Rt. Hon. Secretary of State
Secretary of State for Energy Security and Net Zero
55 Whitehall
London
SW1A 2HP

Our Ref: IP Reference-20053931
Your Ref: EN020028
Please Ask For: Steve Smth
Telephone: [REDACTED]
Email: [REDACTED]@fylde.gov.uk
Date: 07 August 2026

**Morgan and Morecambe Offshore Wind Farms Transmission Assets Development Consent Order
Response to SoS Consultation of 20 May 2026**

Figure 1-7: An indicative layout of the proposed measures at Crossens Outer and Banks Marsh

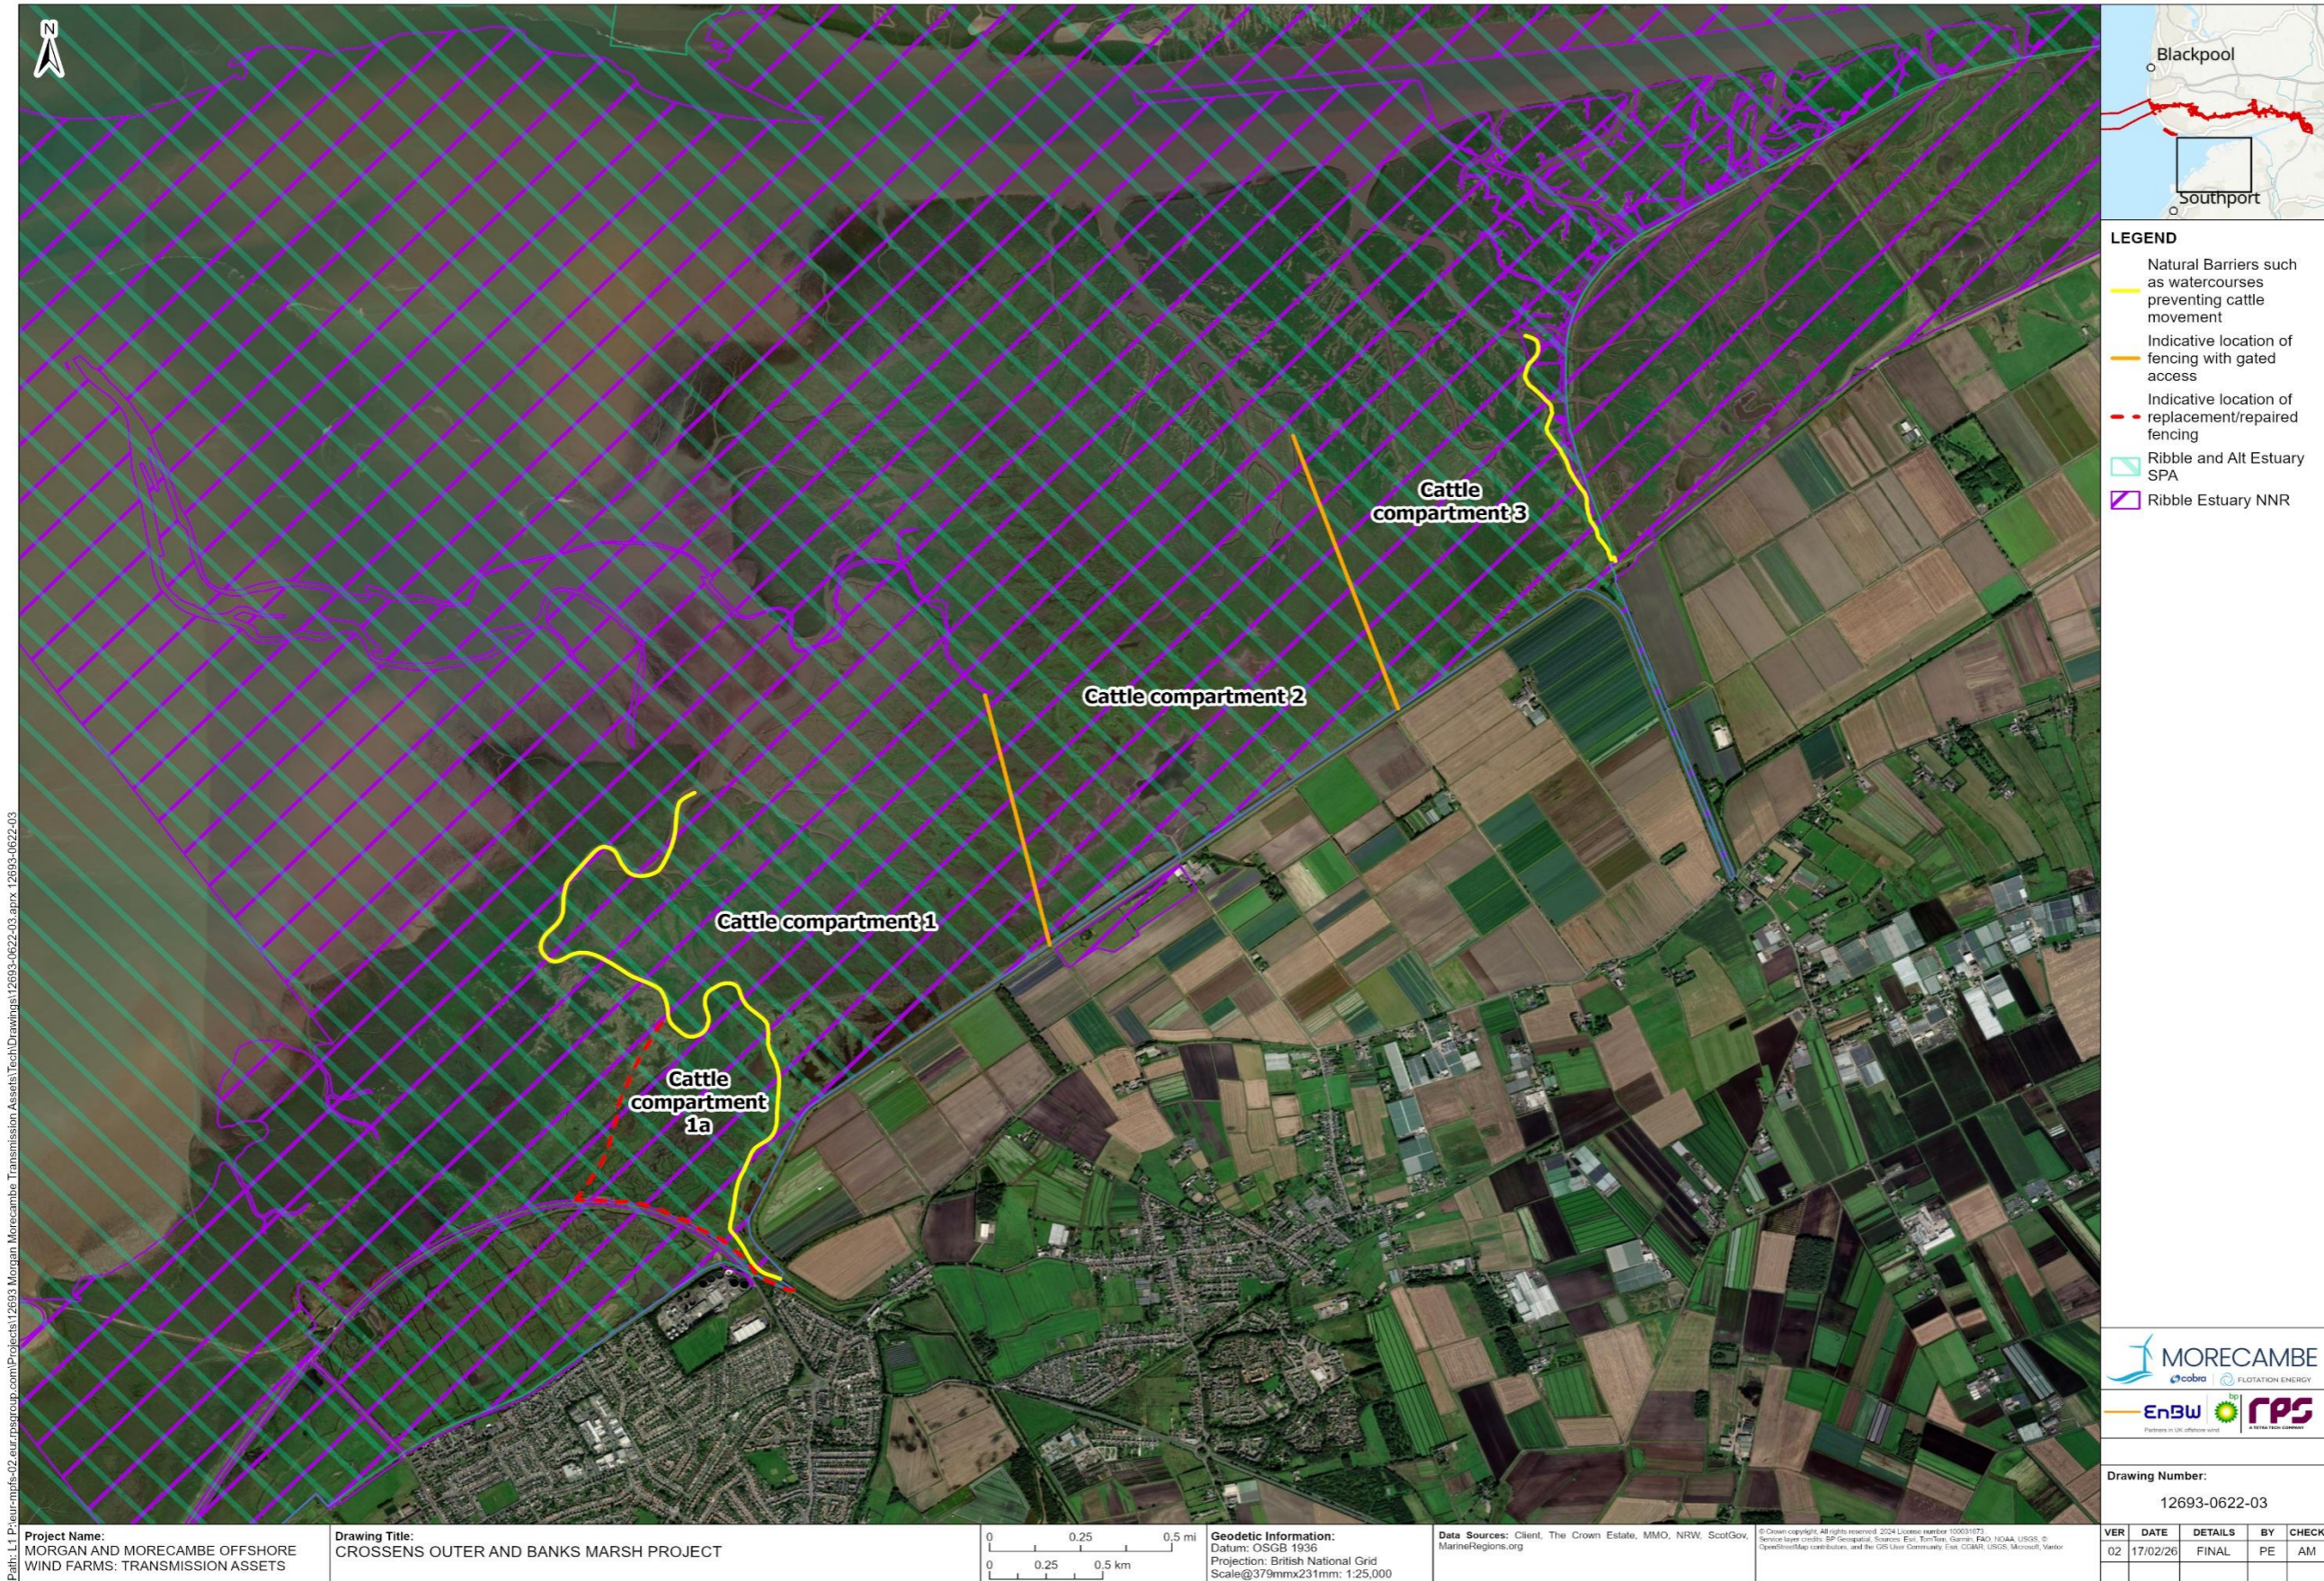
Sections 1.3.2.41 and 1.3.2.49 [C2-092.2] repeated the assertion that NE had agreed that the loss of land would not represent an AEoI but as set out earlier in this response, that assertion was incorrect. For these same reasons, the update to the Alternative Ornithology Mitigation Note [C2-029.23] was flawed, as highlighted by the alleged justification set out in Section 1.1.1.2 of that report.
